# CITY OF ALBUQUERQUE

Site: Sundance Construction Beverly Hills

**Re: Drainage Ordinance (14-5-2-1) Violations for Erosion and Sediment Control**

C-103

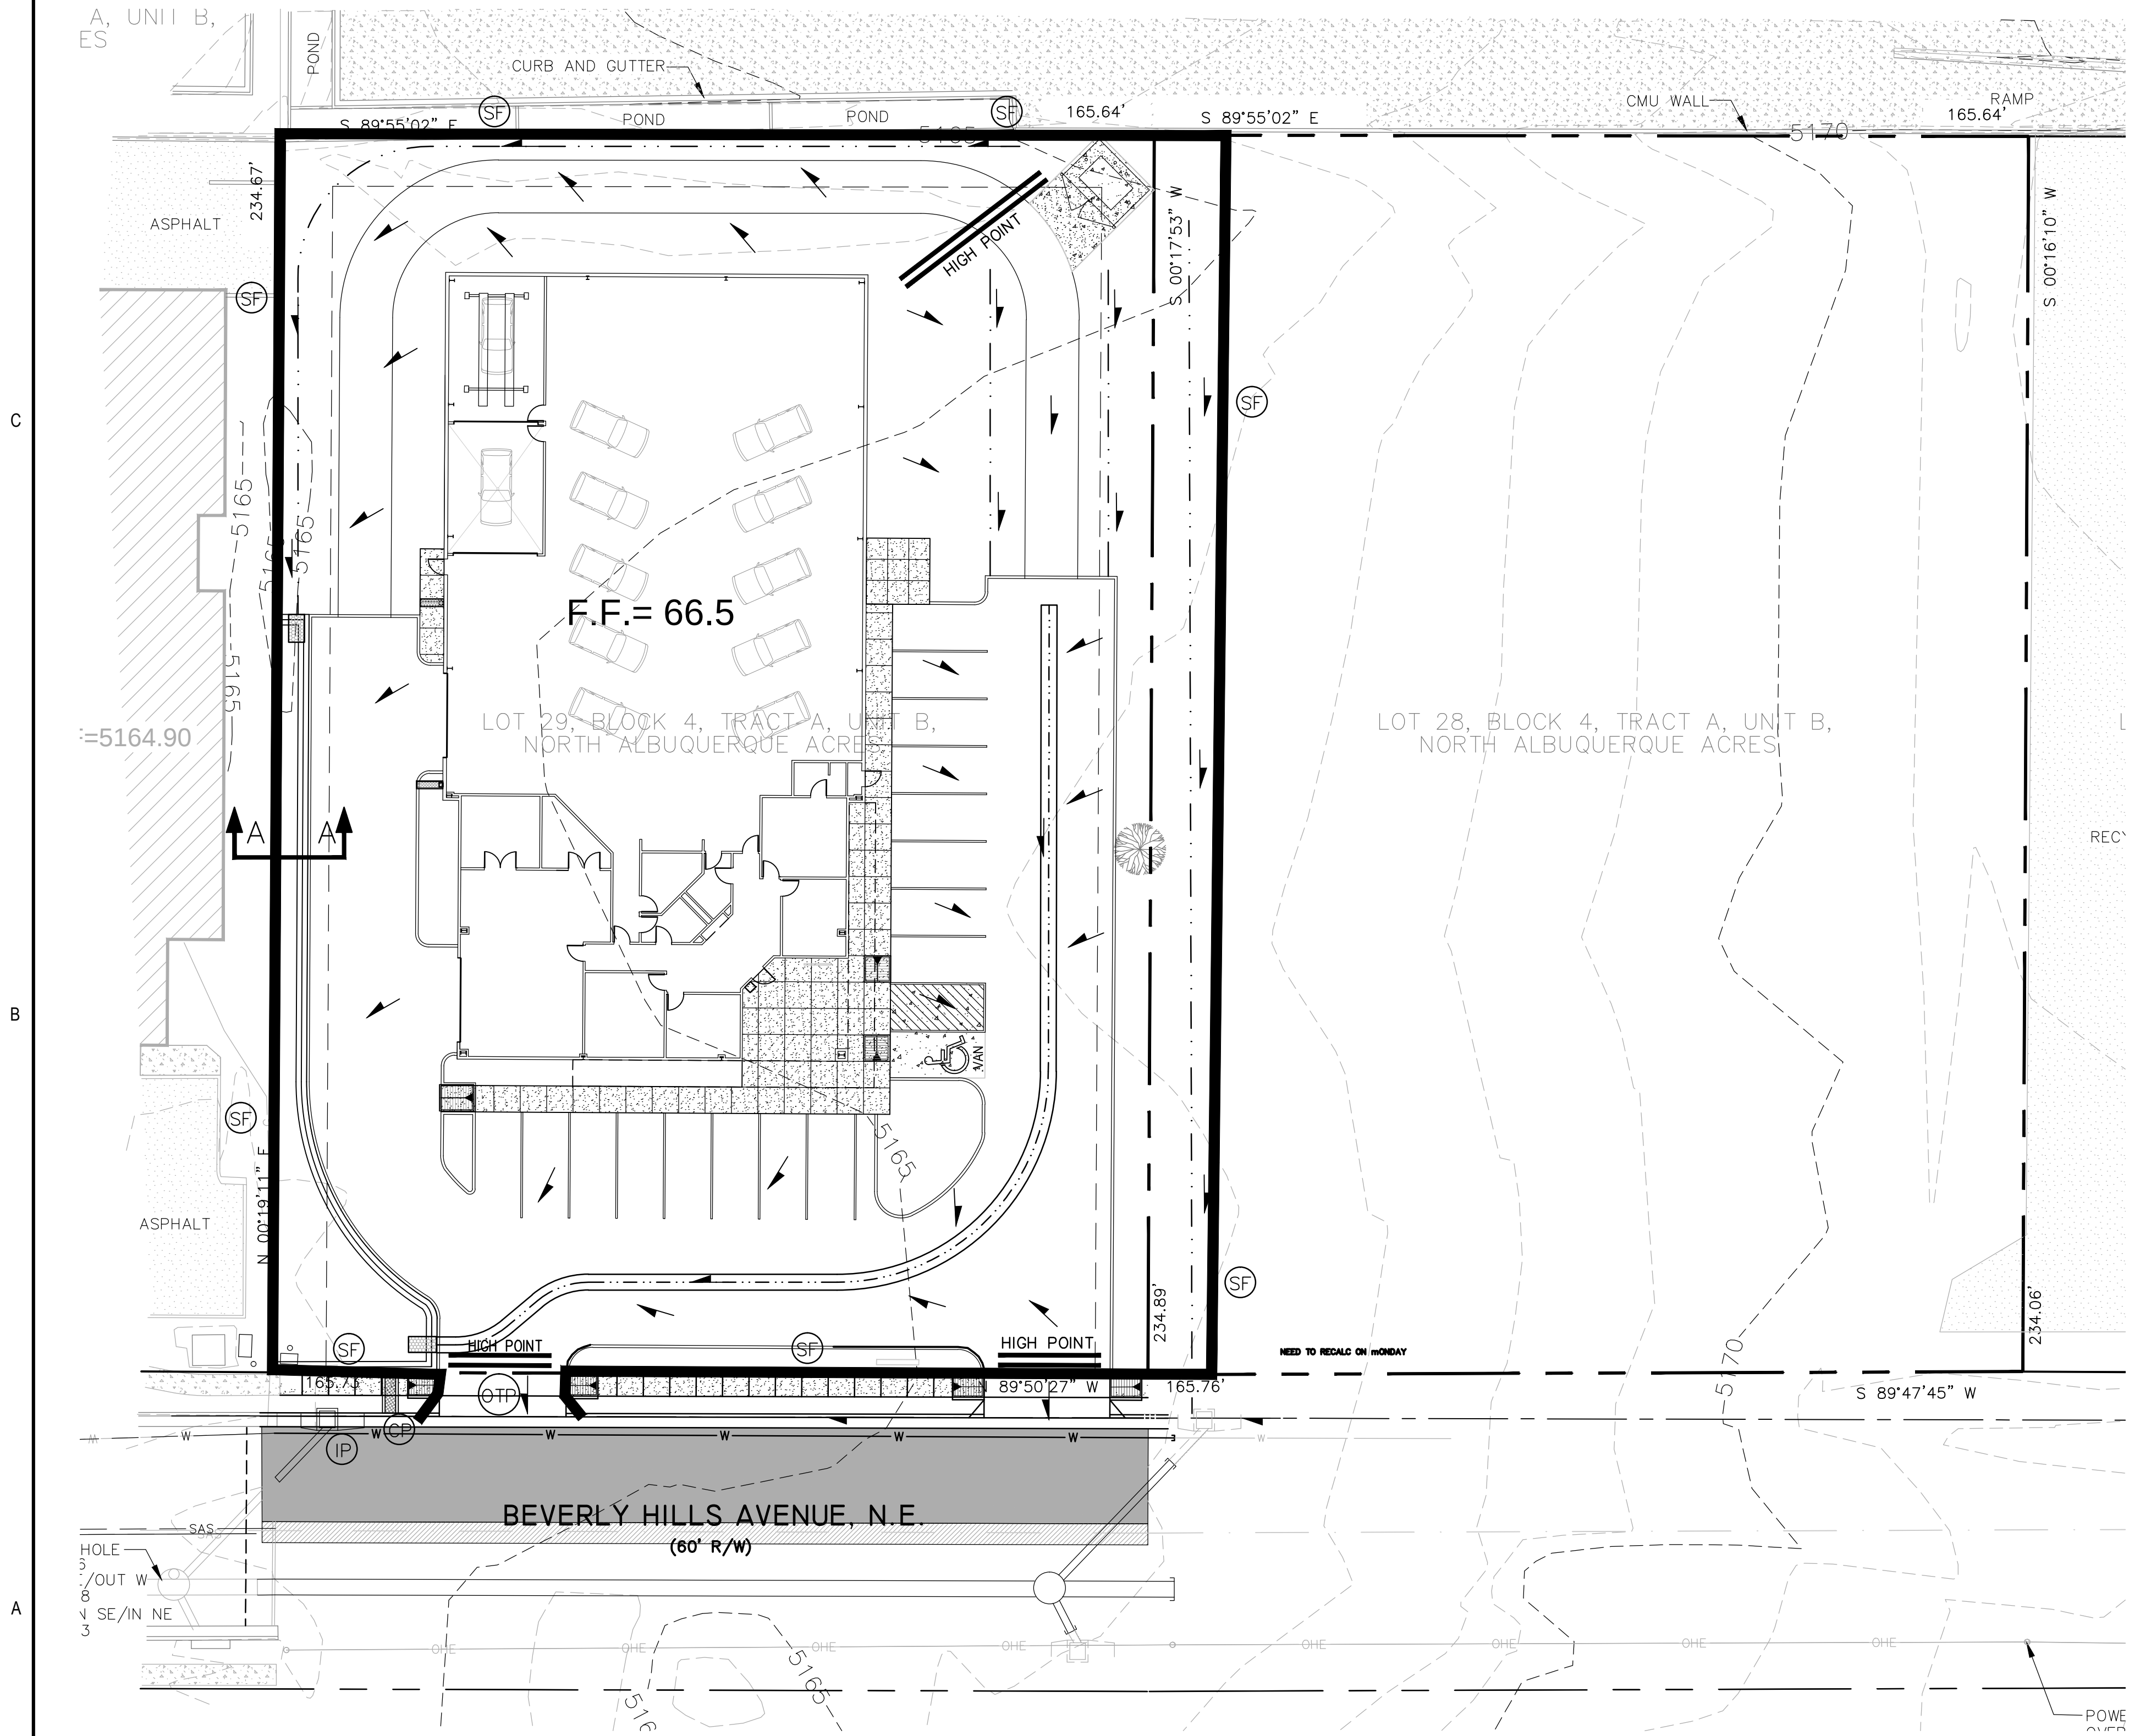
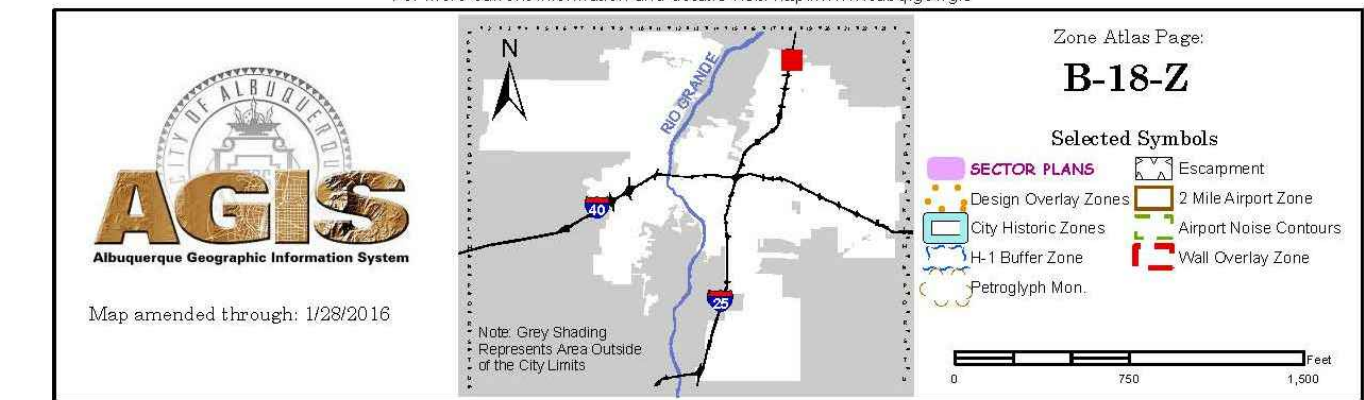
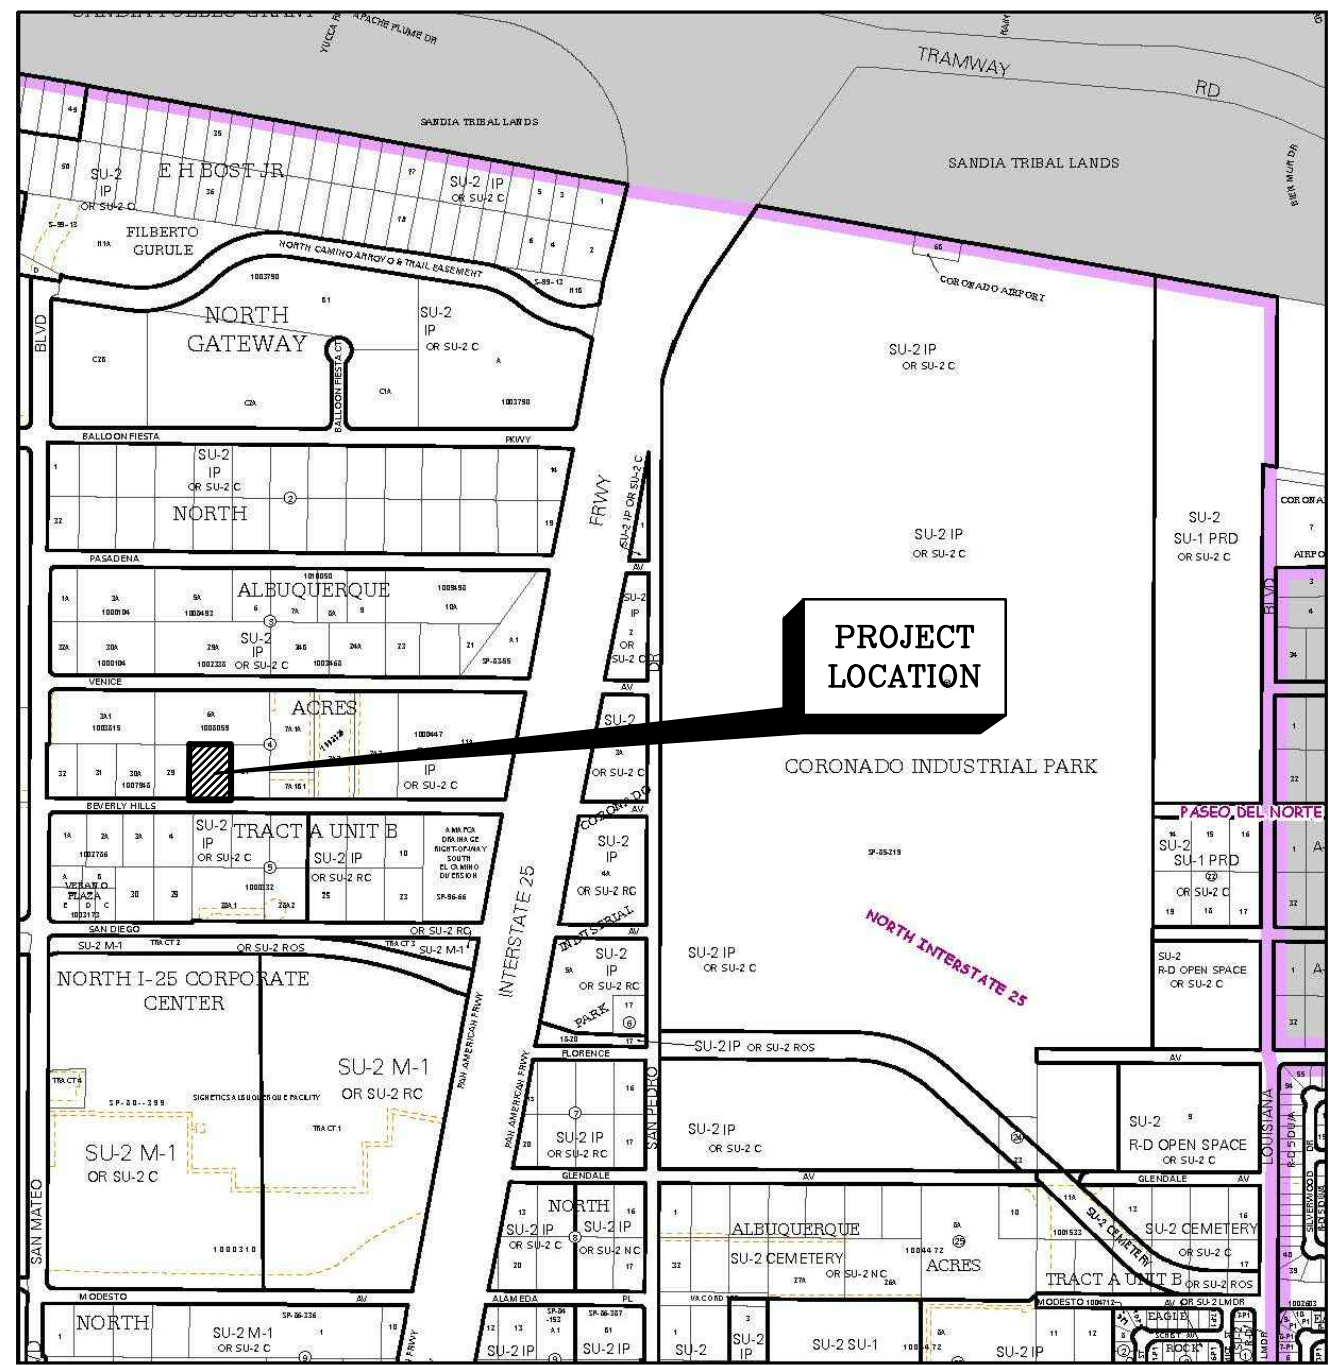
1. Gap in silt fence at the southwest corner of the site and no pond per the approved Erosion and Sediment Control plan. During the storm on May 21st, sediment was discharged to the City street at this location
2. Earth disturbance on the adjoining lot to the east, which is outside the approved Erosion and Sediment Control boundaries and there are no stormwater controls.
3. Self-inspection reports were not provided upon request.

Gap in silt fence at site discharge location.

Sediment discharged to City street during storm on 5-21-18.

Grading of the site to drain to the southwest corner and there is no pond.

Adjoining lot to the east disturbed/graded as part of the site grading.

Area where a sediment BMP (silt fence is required).

1. Close the gap in the silt fence at the southwest corner of the site and grade the pond per the approved Erosion and Sediment Control plan.
2. Provide a sediment BMP for the earth disturbance on the adjoining lot to the east as shown in the last photo.
3. Provide self-inspection reports.
